Road Safety Audit Stage 1

Location: Bairds Farm Shop / New Care
Home Access A259 Crookthorn Lane,
Littlehampton
Section 278 Highway works with extra
shared pedestrian/cycle paths

Produced for Brackley Investments

Report Title: Stage 1 Road Safety Audit
Section 278 Highway Works with pedestrian /cycle paths

DRAWING TITLE
Highway Improvements

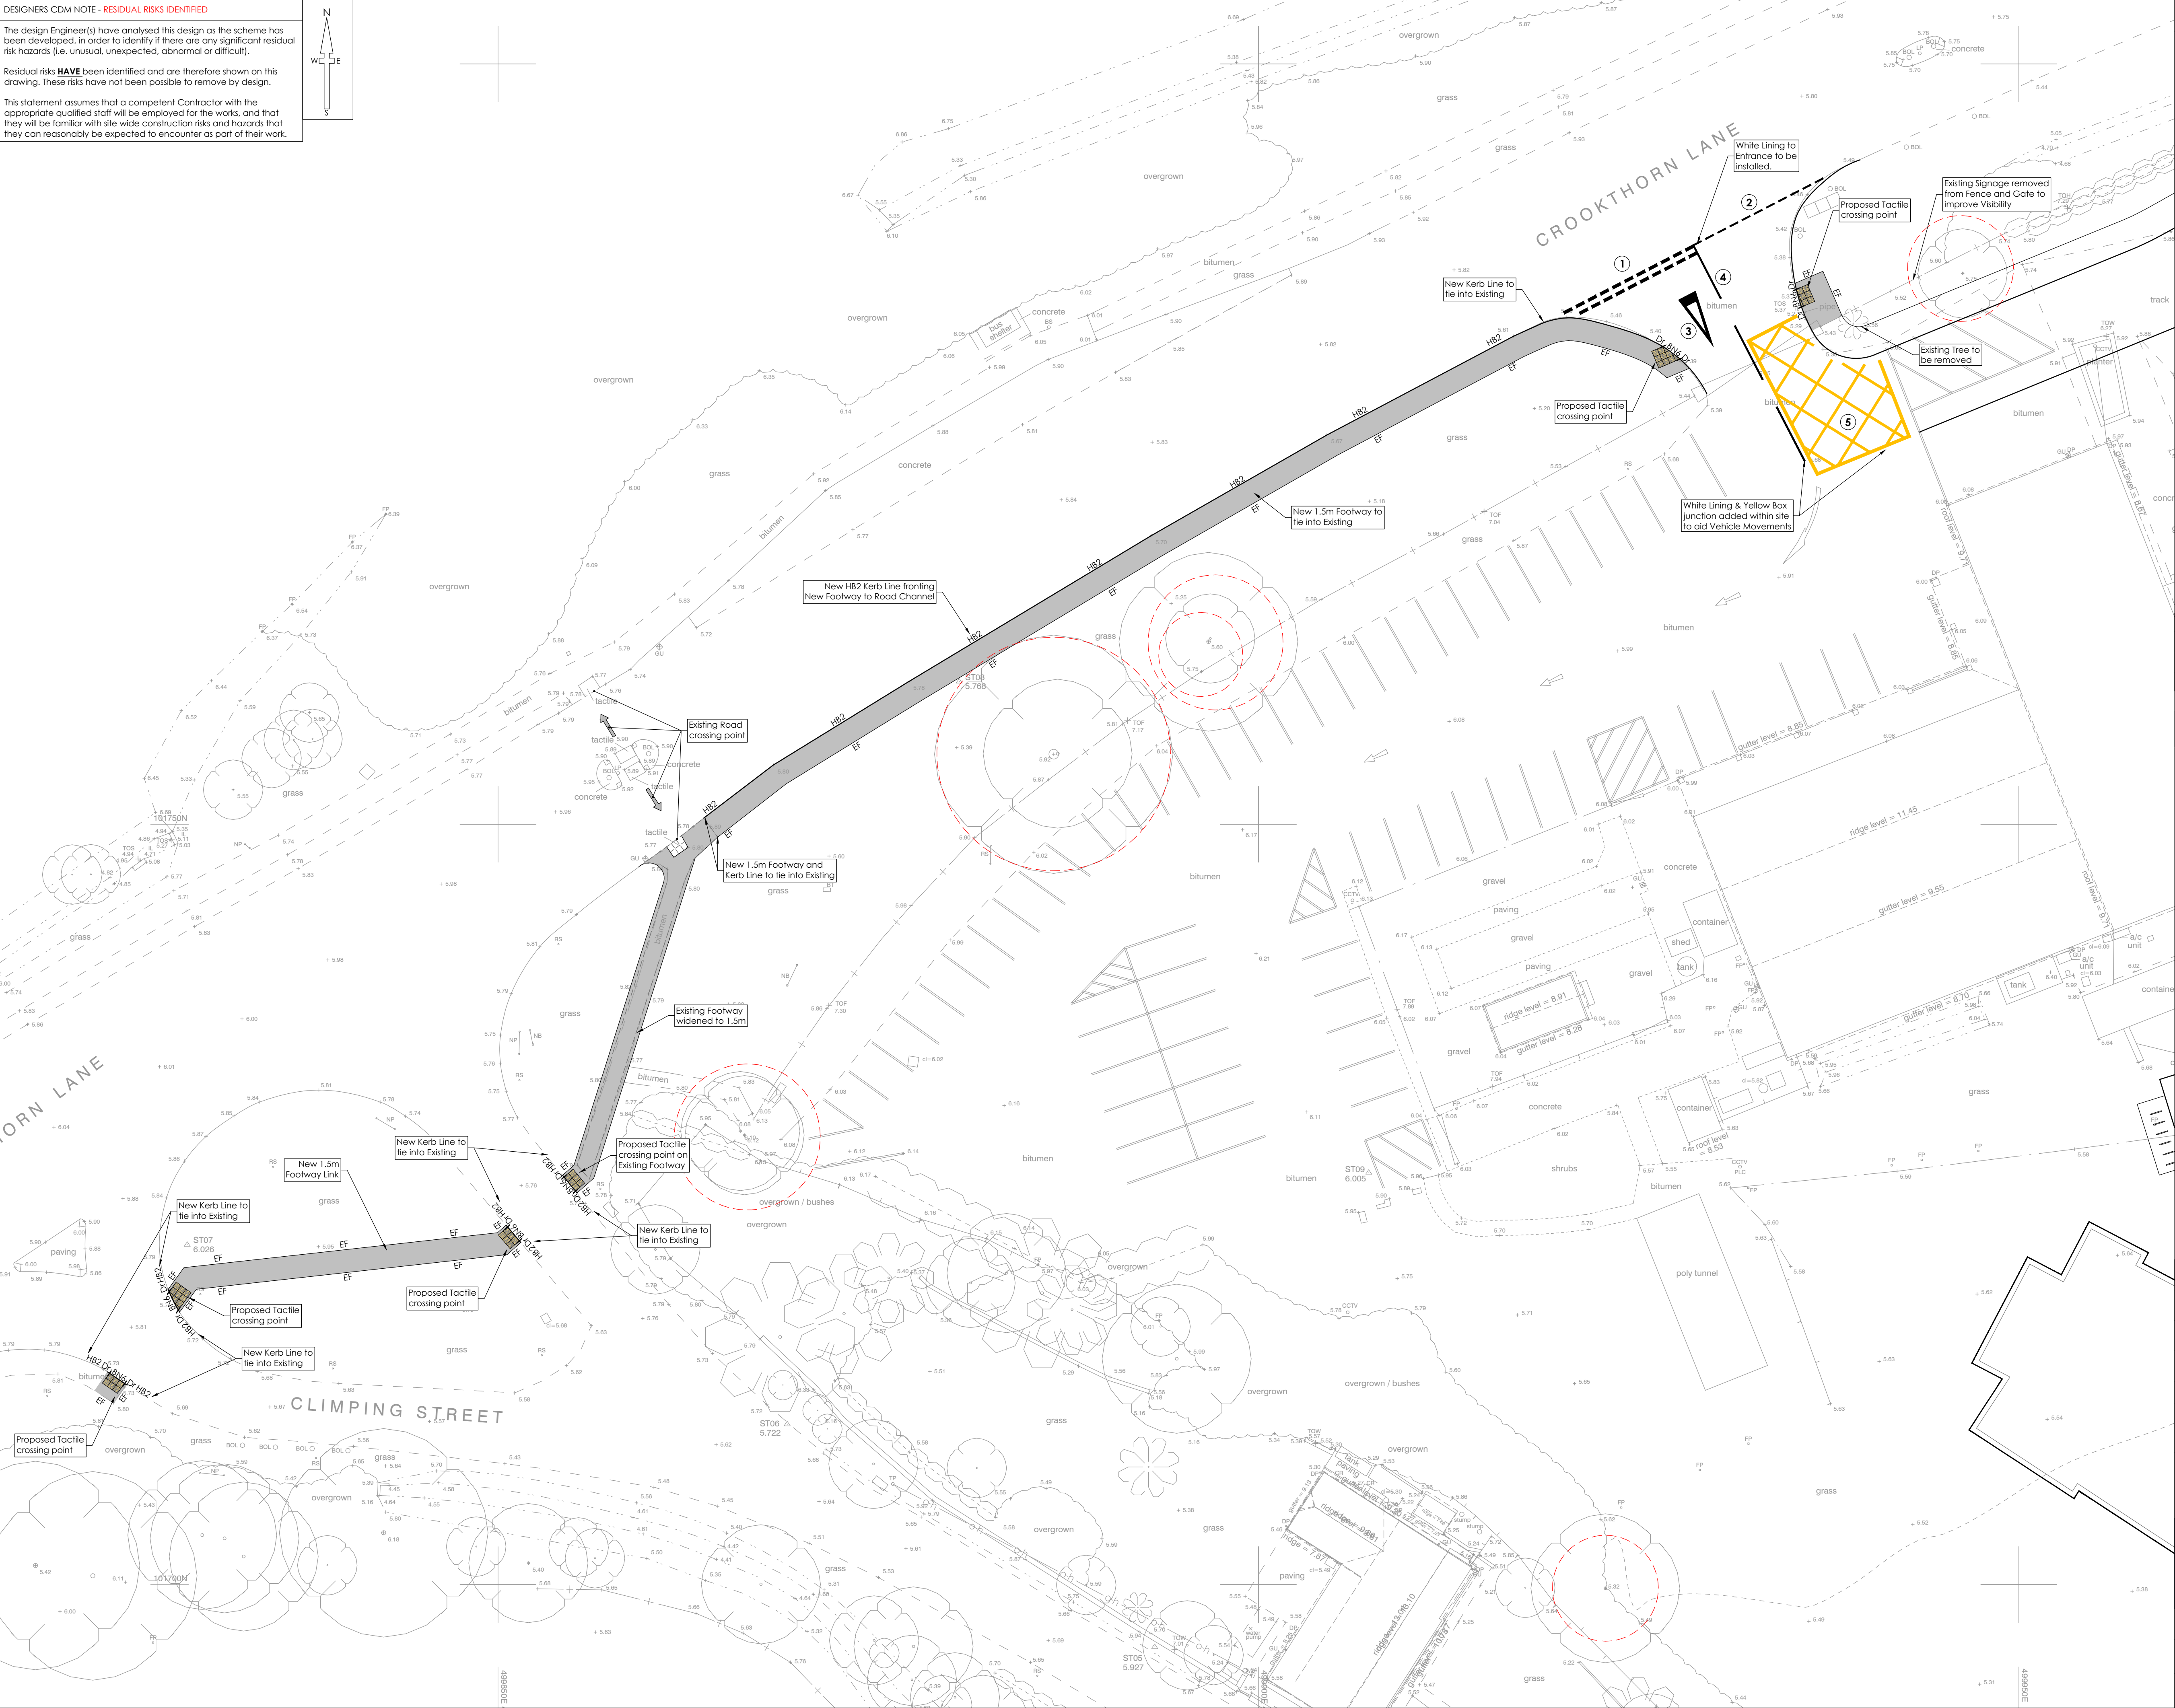
8.1 *Problem* (item A1.4)

Summary: No new drainage detailed to prevent surface water ponding adjacent to new kerblin

Description: A new kerblin is detailed along A259 and at the shop access. This kerblin will cause problems with surface water being retained on the main carriageway. Appropriate drainage needs to be provided at the detailed design stage to prevent ponding on the main carriageway and within the access

Recommendation: Provide appropriate drainage at detailed design stage

8.2 *Problem* (item A 1.12)

Summary: No cycle path provision to Climping Street or east side of Farm Shop access to crossing point

Description: A new share use cycle path is detailed along the southern side of A259 from the western refuge /crossing point to the Farm Shop. This path does not link upto Climping Street where cycles may be expected to go after crossing the road to head to the beach. There is also no cycle provision for cycles arriving and exiting to go east from the Farm Shop as

only a pedestrian footway is proposed and cyclists will use this path as it is more direct rather than having to go west then cross road and come back on themselves. Provide additional lengths of shared use path

Recommendation: Provide additional lengths of 3m wide shared use cycle paths

8.3 *Problem* (item A4.2)

Summary: Level difference to rear of new path

Description: A new 3m wide path is detailed that will crossfall to the carriageway. There will be a level difference to the rear of the new path that will require the adjacent verge to be regraded to remove hazard to rear of path

Recommendation: Regrade verge to rear of new path

8.4 *Problem* (item A4.2)

Summary: No shared path signs or corduroy paving detailed along shared use path

Description: A new shared use path is detailed with only standard blister tactile paving at the crossing point. Current guidance recommends shared use signs and corduroy paving be installed along shared use paths to ensure pedestrians and those visually impaired are warned of the presence of cycles

Recommendation: Provide appropriate signs /corduroy paving along shared use path

8.5 *Problem* (item A4.3)

Summary: Inadequate size refuge island for cycles to cross

Description: A new shared use path is detailed along the southern side of A259. Cycles will have to use the existing inadequate size refuge island to cross over the road between cycle paths. This island needs to be increased in size to include a minimum of 2m width and 3m length standing area to cater for cycles

Recommendation: Increase size of refuge island to cater for cycles.

8.6 *Problem* (item A4.3)

Summary: Poor surfacing inline of proposed crossing point

Description: A new footway and pedestrian crossing point is detailed across Climping Street. The existing carriageway surfacing is in poor condition and has potholes in line with the new crossing point that will be a trip hazard to pedestrians. This surfacing needs to be repaired

Recommendation: Fix potholes (Local Authority responsibility).

8.7 *Problem* (item A5.1)

Summary: New island needs to have high level keep left sign to make it more visible

Description: A new refuge island is detailed on the A259 which has a 40mph speed limit with many vehicles travelling faster. The new refuge needs to have high level keep left signs to ensure it is more visible to approaching drivers to avoid collisions (Same as the island it is replacing)

Recommendation: Provide high level keep left signs

8.1	No new drainage detailed to prevent surface water ponding adjacent to new kerbline	The existing carriageway simply drains onto the adjacent verge as there is no formal piped drainage within the area. New proposals seek to replicate this with gullies draining onto the swale depression behind the new footway/cycleway

8.2	No cycle path provision to Climping Street or east side of access to crossing point	Cycle path extended to the west and east
8.3	Level difference to rear of new path	Area to be graded behind the back edge of cycle path

8.4	No shared path signs or corduroy paving detailed along shared use path	Signage and corduroy paving added to the plans. Exact details to be agreed as part of S278 agreements

8.5	Inadequate size refuge island for cycles to cross	Refuge within both islands increased
8.6	Poor surfacing inline of proposed crossing point	No action. Highway maintenance issue

8.7	New island needs to have high level keep left sign to make it more visible	High level keep left sign added to proposals
